This supplementary planning submission relates to the revised drainage proposals submitted by the applicant on 25th November 2022. It should be read in conjunction with all our previous comments regarding the drainage proposals for this site. For clarity we re-iterate that:

Detail
ROAD & SEWER FEASIBILITY PLAN

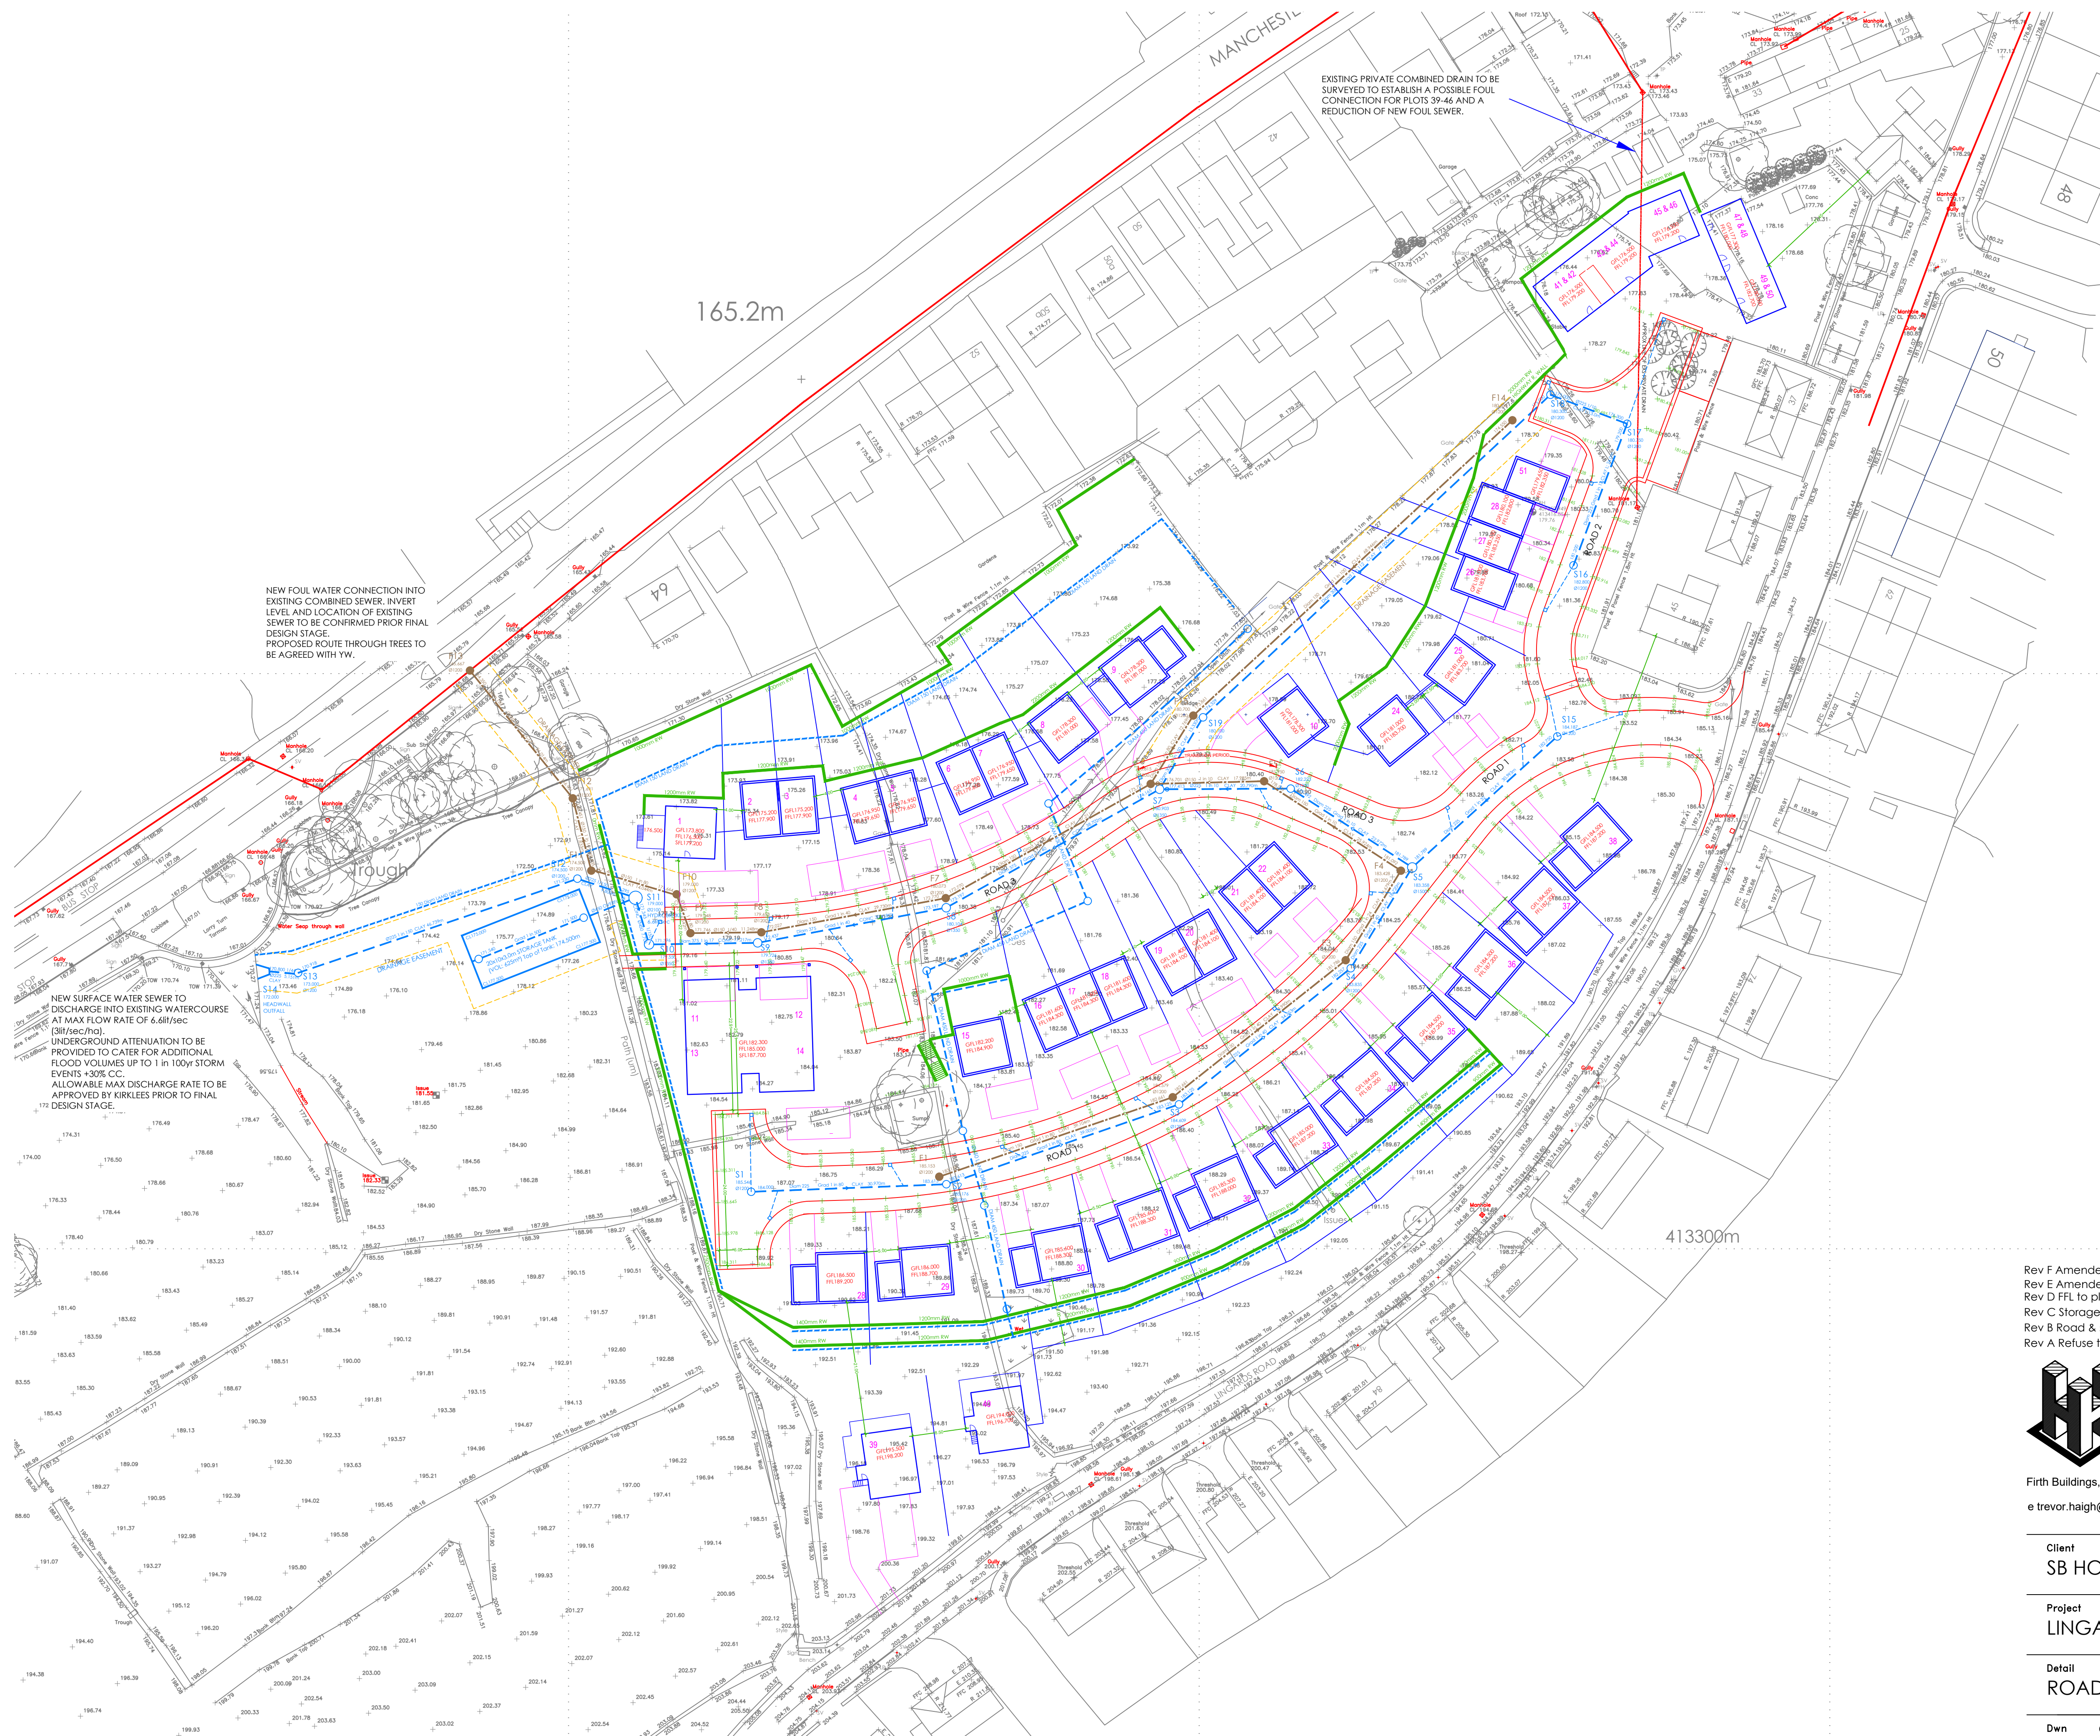
- **Receiving Watercourse.** There is still no evidence that the watercourse running down through the cemetery can accept the increased run-off from the development, plus the added/diverted land drainage and/or diverted exceedance flows. We are staggered that there has been no attempt to survey this watercourse, as it is in an extremely sensitive location, where the consequences of "overtopping, erosion and culvert blockage" could be catastrophic. **The risk is enormous both to the cemetery, the graves within the cemetery and the viability of the development. If this watercourse is not adequate, it will simply veto the entire development, as there are no other practical options for dealing with the whole combined surface water and land drainage flows (apart from taking the entire "clean water" flow all the way down to the River Colne).**

- **Land Drainage system.** The proposed land drainage system is spatially comprehensive, but poorly designed. It starts off as a 450mm pipe at the top end of the site (in the garden of plot number 37) and is joined by two lateral 150mm land drains before discharging into the

“open water channel” that runs across the site. A further 150mm land drain connects into the open water channel, close to a simple “overspill weir” at the boundary of the site. Overspill flow can then run overland down the hill (through the garden of plot number 8) before theoretically being absorbed in to a 300mm land drain and ultimately a 375mm “culvert”. This arrangement is quite simply bizarre and is almost certain to lead to flooding of plot number 8 and numbers 50b & 52 Manchester Road. Flood flow will simply “jump over” the inverted soakaway manhole at the bottom of the garden of plot number 8. It is therefore not a viable drainage design, even without the problems of future root ingress referred to in Kirklees Council’s Lead Flood Authority comment published on 1st December. We support the Lead Flood Authority’s requirement for a 5metre clear planting distance, but fear that it will be almost impossible to deliver in practice, because of the conflict between the extensive land drainage proposals and the on-site landscaping requirements. NB: As a rule, downstream pipes should always be larger than upstream pipes.

- **Exceedance Flows.** The developer clearly still does not understand the purpose and structural requirements for exceedance flow routes. They are more than pretty, pink arrows, loosely drawn on a “flood route plan”. They must actually work in extreme flood conditions. Firstly and critically, they do not end at the boundary of the site. As it stands the flood route plan merely confirms that exceedance flood flows are likely to inundate the gardens and surroundings of plots 1, 8 and the area around the flats at the Eastern end of the site. They will also inundate the off-site gardens of numbers 50b, 52 and possibly 64 Manchester Road, Far Lower Wood Farm, Lower Wood Farm cottages and Pippin Cottage. This is partly because the developer has simply not considered the impact and routing of exceedance flows once they leave the site. Secondly if a flood route is to be effective it needs to be supported by physical infrastructure such as higher kerb lines in key places, avoidance of “dropped” kerbs which lead to driveways sloping away from the intended route and physical reinforcement of flood routes in vulnerable areas – e.g. steep unpaved / grassed slopes, steps and areas with underlying critical infrastructure. A particularly vulnerable point within the plans is the co-existence of the main flood exceedance route and critical foul and surface water outfall routes. In simple terms we are pleased that the developer has recognised the need, but the plans need to go much further before we can say that the proposals will actually work and meet SUDS requirements.

- **Attenuation Tank** The developer has argued that the attenuation tank is underground and is therefore not visible (in the green belt). This is extraordinarily dismissive and wrong. He has (on 1st December) submitted a new cross section through the tank, which clearly shows the land profile will have to be significantly changed and raised by up to 2.5 metres. We say that this is unacceptable, given that the proposed site of the attenuation tank is green belt land

even though it does not actually need to be sited on green belt land. It could be sited under the road serving the site. The concrete wall of the tank may not be visible in the green belt but the changed land profile, on an already very steep side slope will be very obvious and overbearing. It is therefore inappropriate development within the green belt. Of equal concern is the finished steep slope of the ground above the tank and between the tank and the access point to the on-site road hammerhead. Attenuation tanks need to be regularly maintained and this requires vehicular access. In our view the proposed finished slope of the ground, and the very steep access to it, makes maintenance access virtually impossible. The tank is therefore not maintainable and will not be adoptable by Yorkshire Water. That means the on-site sewers will not be adoptable either.

- **Private Drainage System** We have previously articulated our concerns about the “private” drainage system at the Eastern end of the site. Our concerns remain valid, as the developer has made no attempt to address them in his latest submissions.
